**Peer Review of Groundwater Vulnerability Study
Richmond Village Well System, Richmond, Ontario**

This letter summarizes our peer review of the report, titled *Groundwater Vulnerability Study, Richmond Village Well System, Richmond, Ontario*, prepared by Golder Associates Ltd., dated March 2012. The peer review objectives are to:

Our File: 12-6360

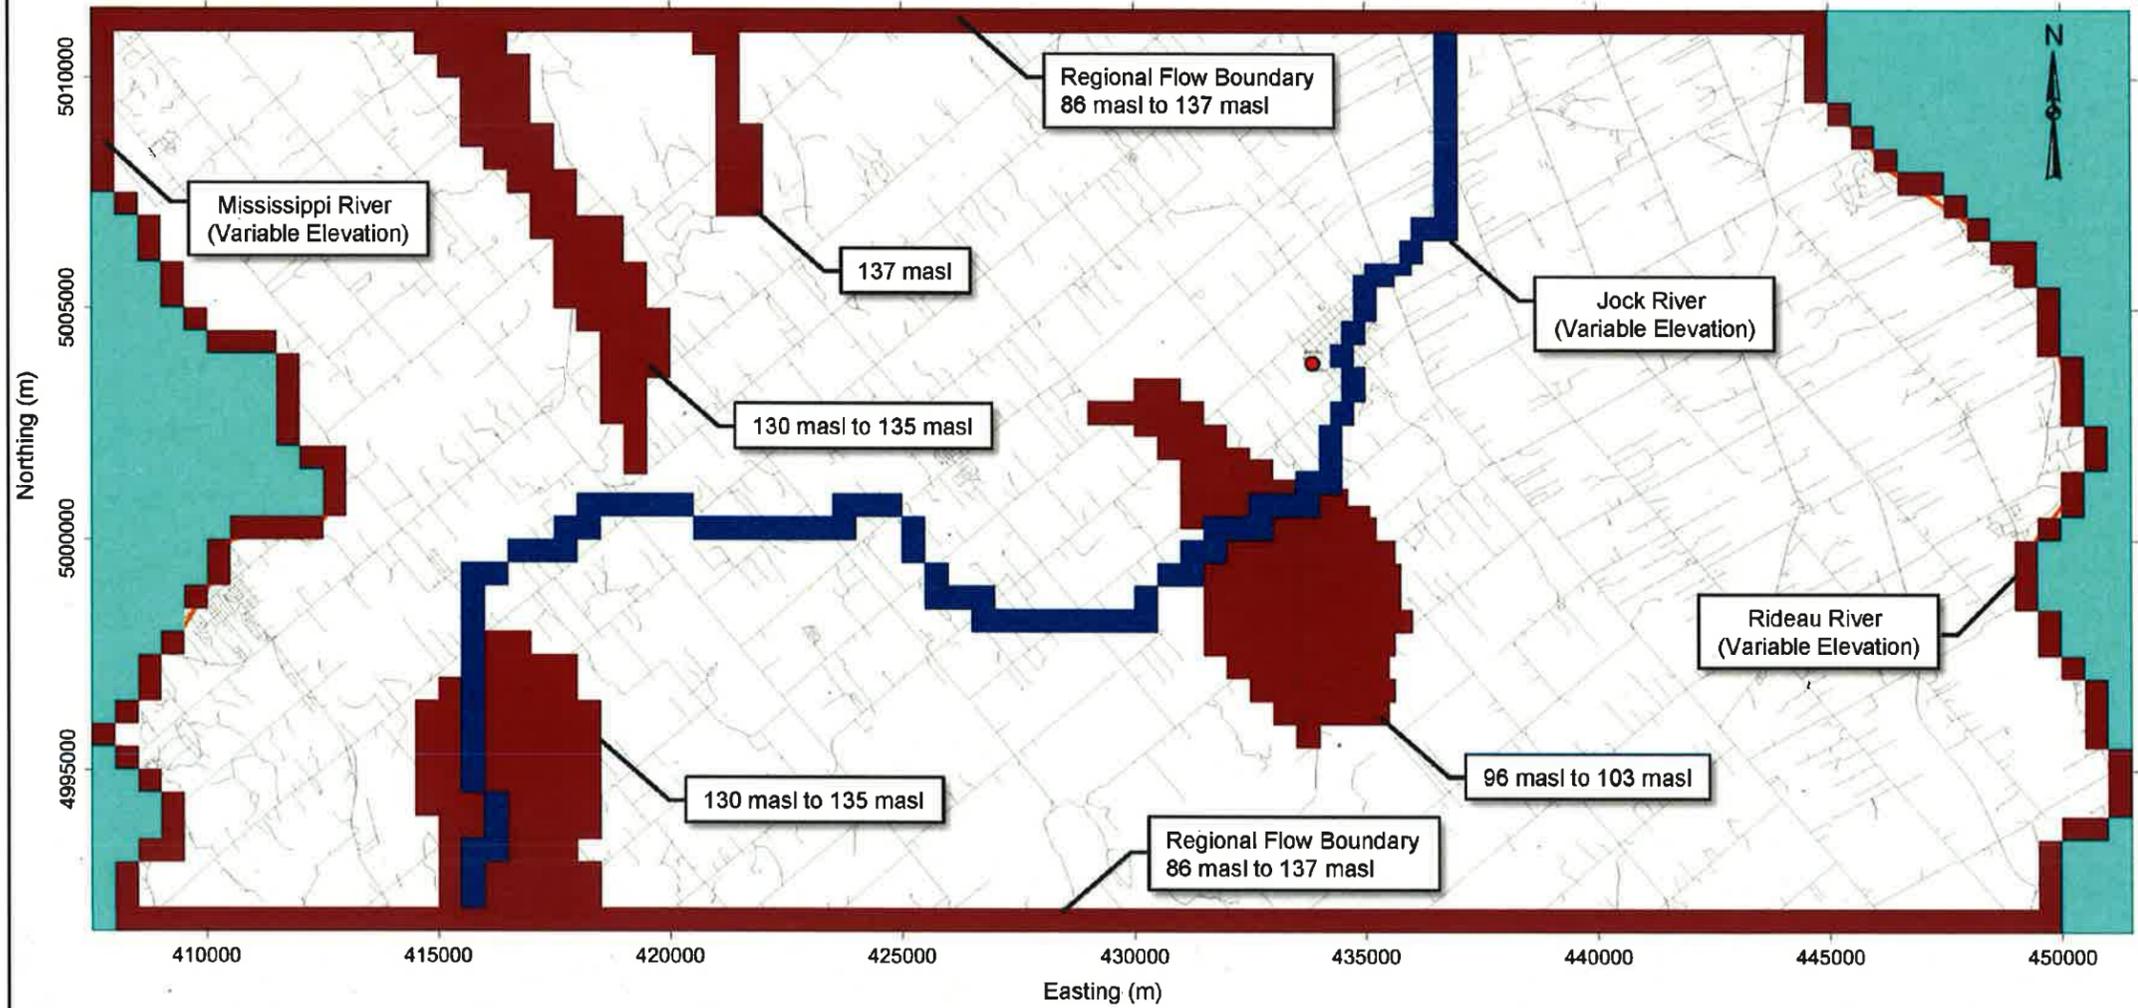
Boundary conditions define input/output zones for the model and MODFLOW allows a number of different types of boundary conditions. Report Figure 13 shows the boundary conditions used in the model. The eastern boundary consists of a 'constant head boundary' representing the Rideau River. Similarly, the western boundary is a constant head boundary representing Mississippi Lake and the Mississippi River. The values for the constant head cells varied to represent the actual stage of both the Rideau River and the Mississippi River.

The northern and southern boundaries were also defined as constant head boundaries and assigned constant head values based on groundwater elevations in the bedrock aquifer map.

In addition to the perimeter boundary conditions, other features were represented in the model. These include the use of a 'river boundary condition' to represent the Jock River which flows through the central area of the model and four large marches/wetland areas which were modeled as constant head boundaries.

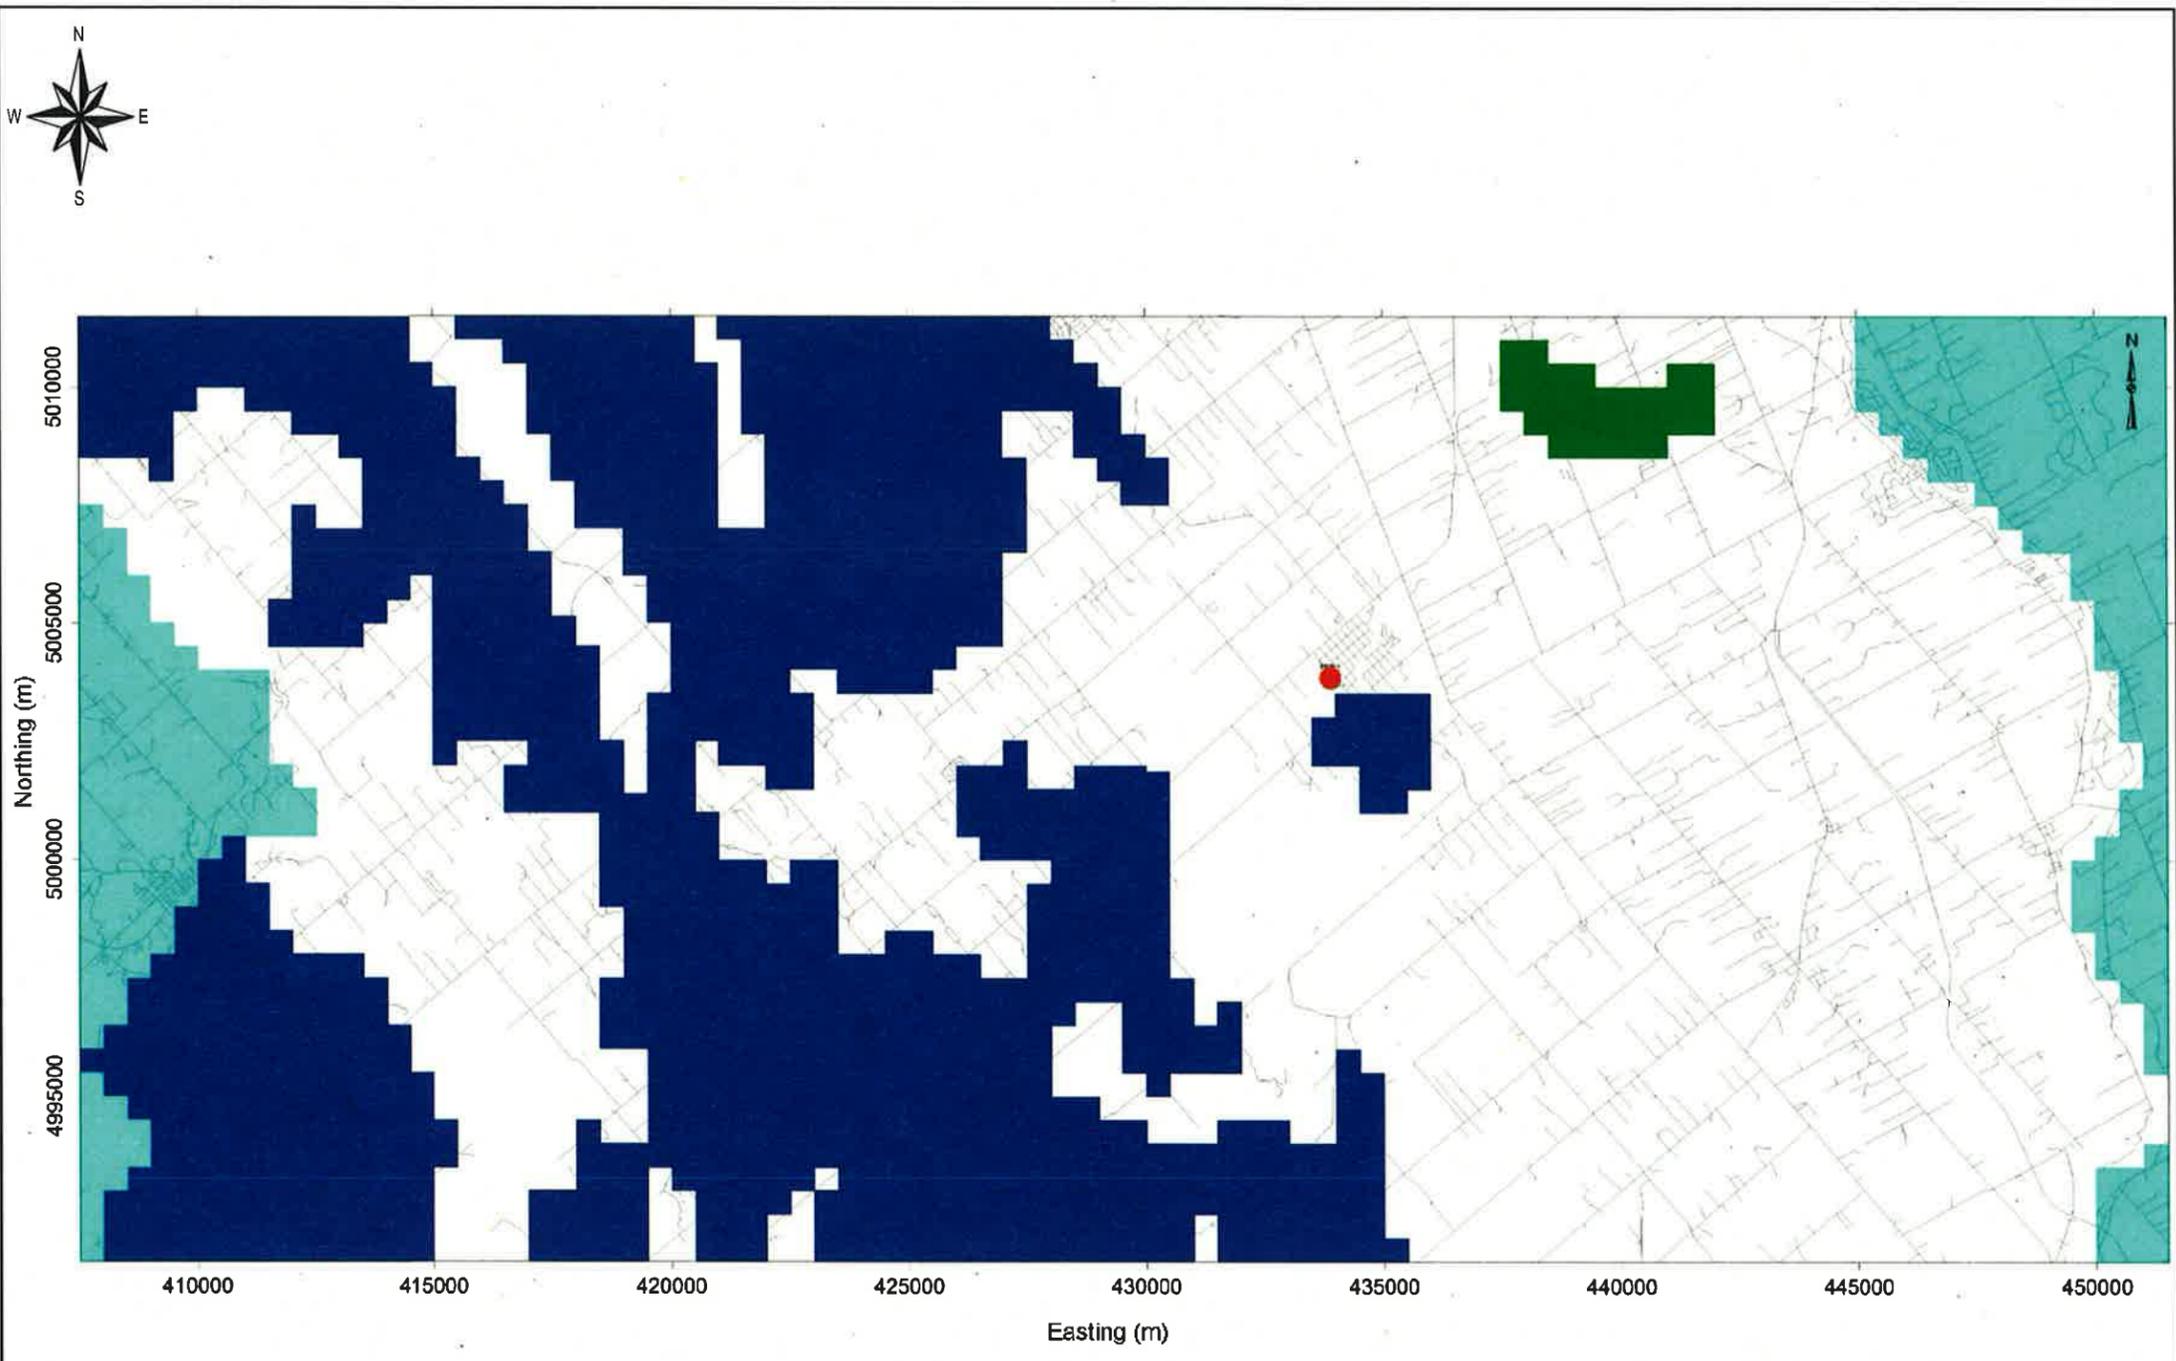
Recharge was defined in the model based on overburden type and thickness. Three recharge zones were designated (report Figure 14) representing clayey overburden located mainly east of Richmond (5 mm/year), till and rock outcrop areas west of Richmond (15 mm/year) and a stratified ice contact deposit located northeast of Richmond (200 mm/year).

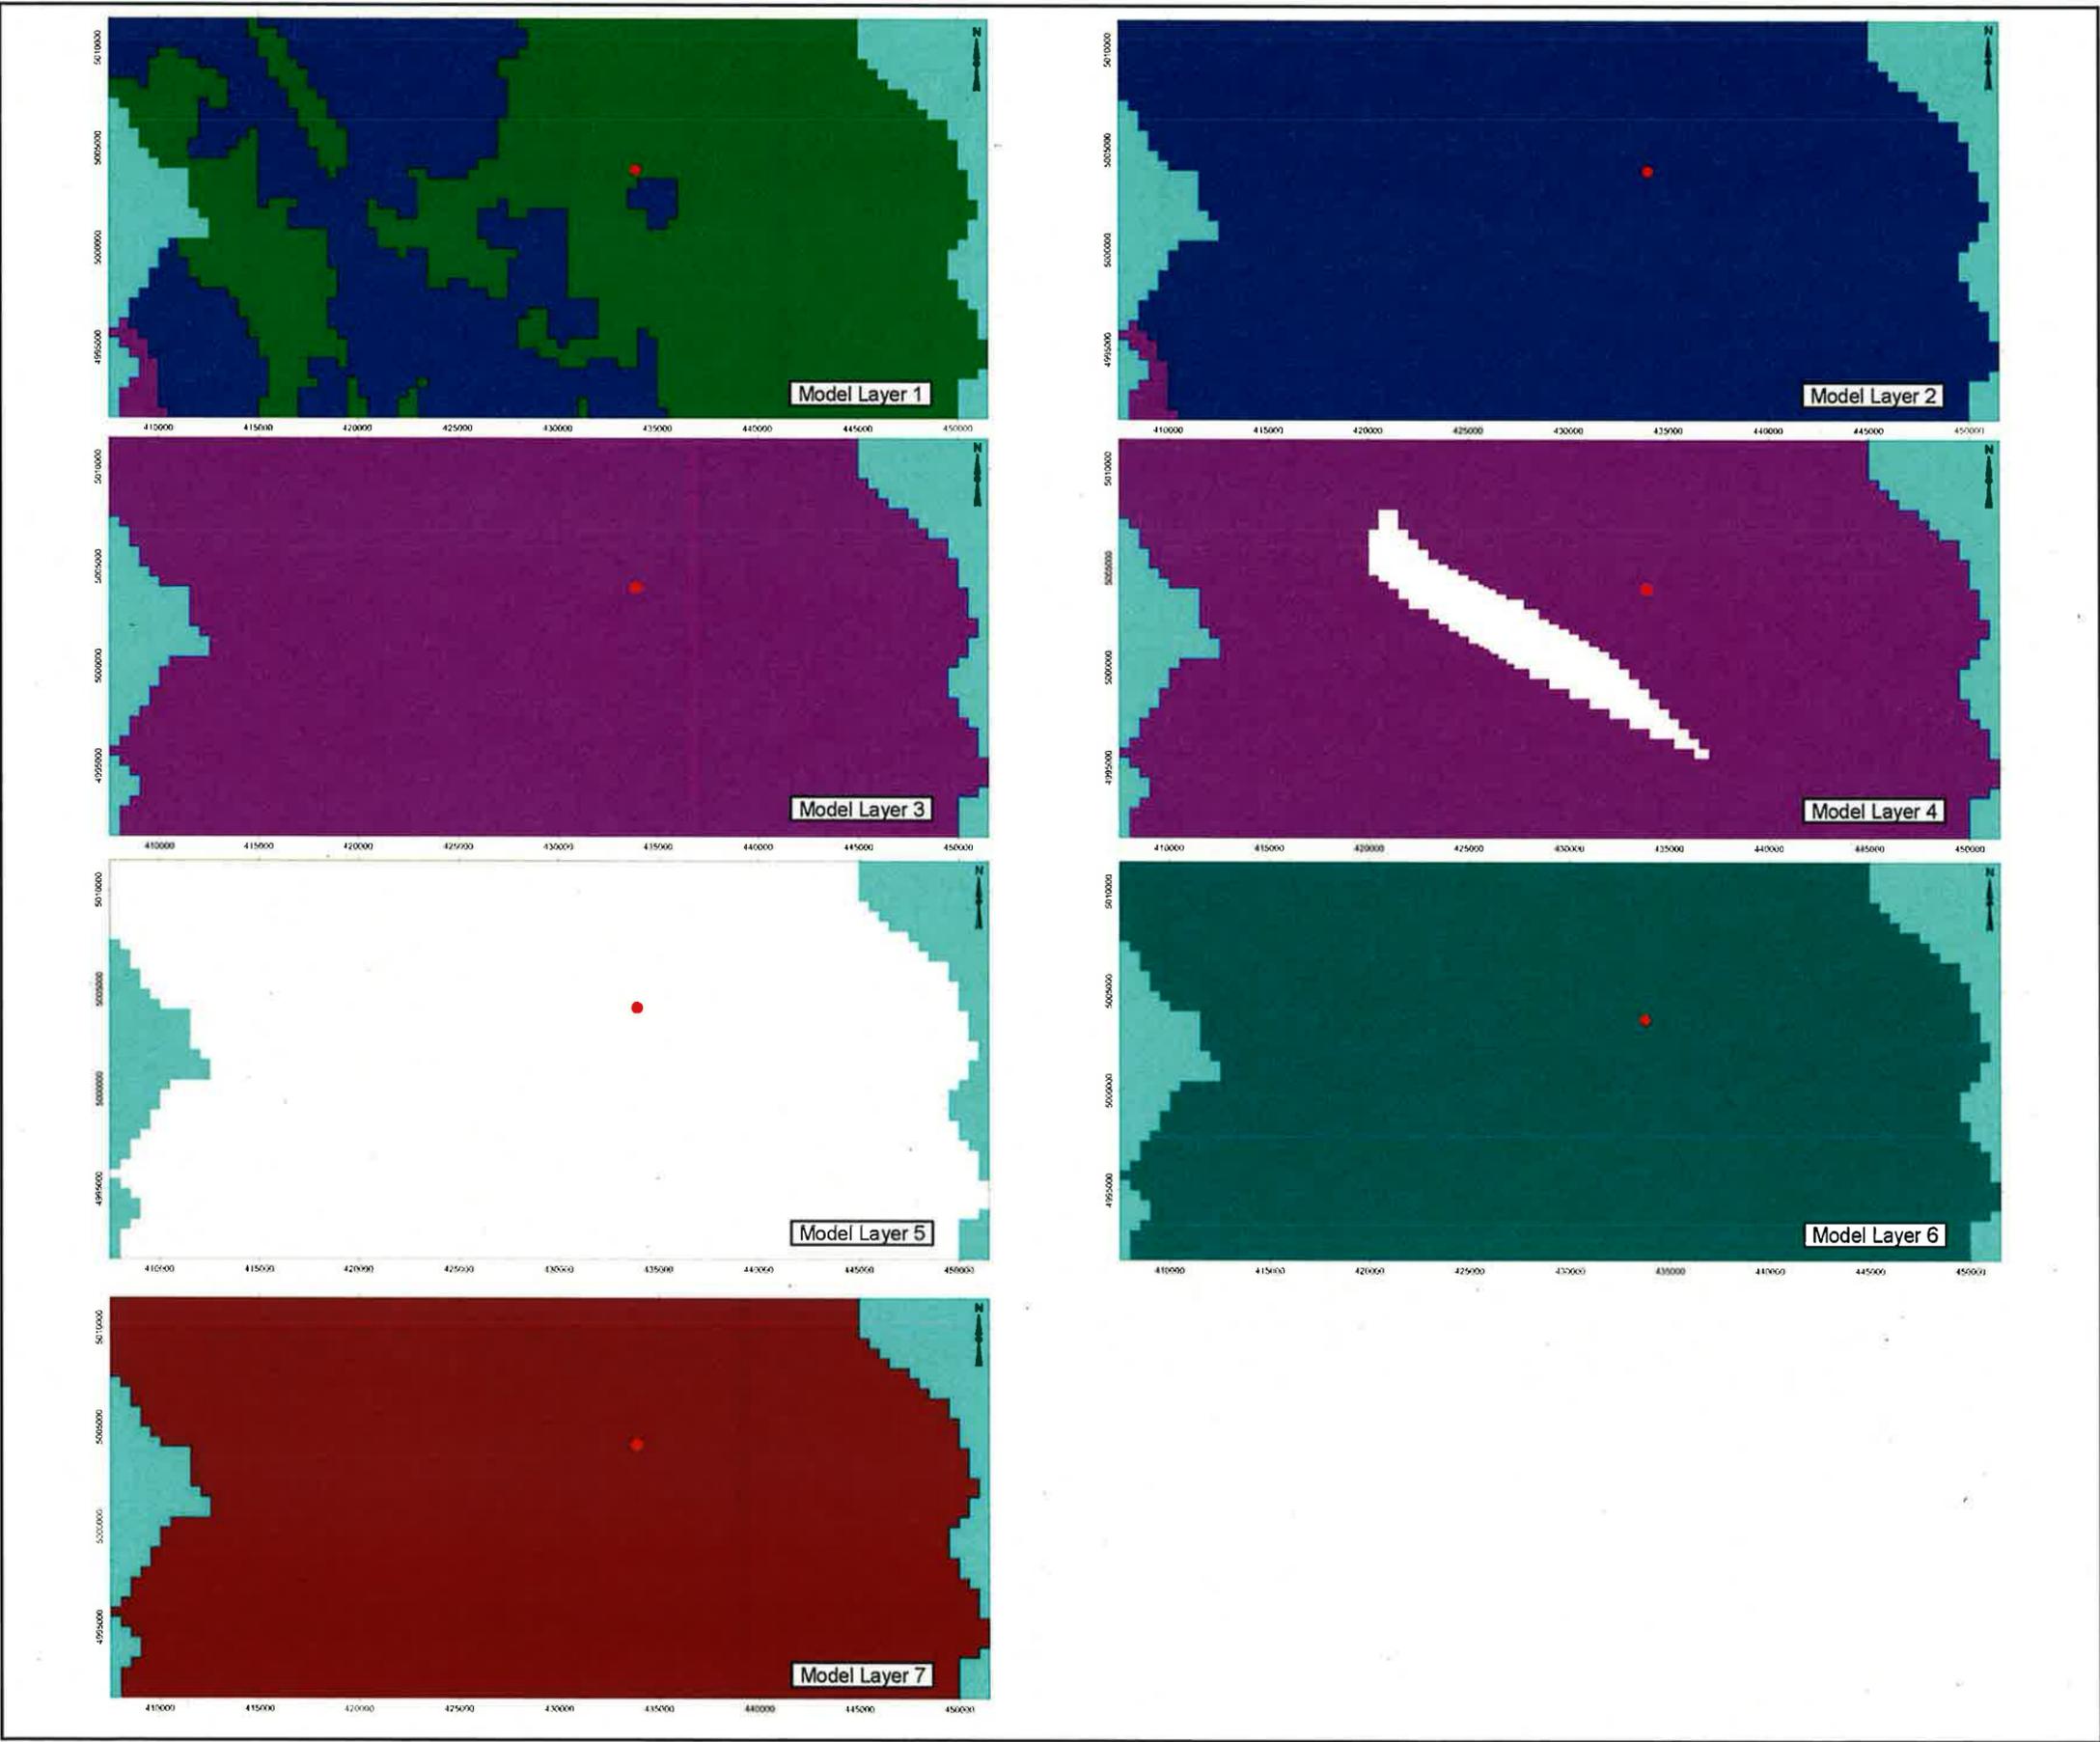
Six hydraulic conductivity zones (report Figure 6 and report Figure 15) were specified in the model: overburden, Oxford / March Formation, Upper Nepean, Lower Nepean, Upper Precambrian and Lower Precambrian.
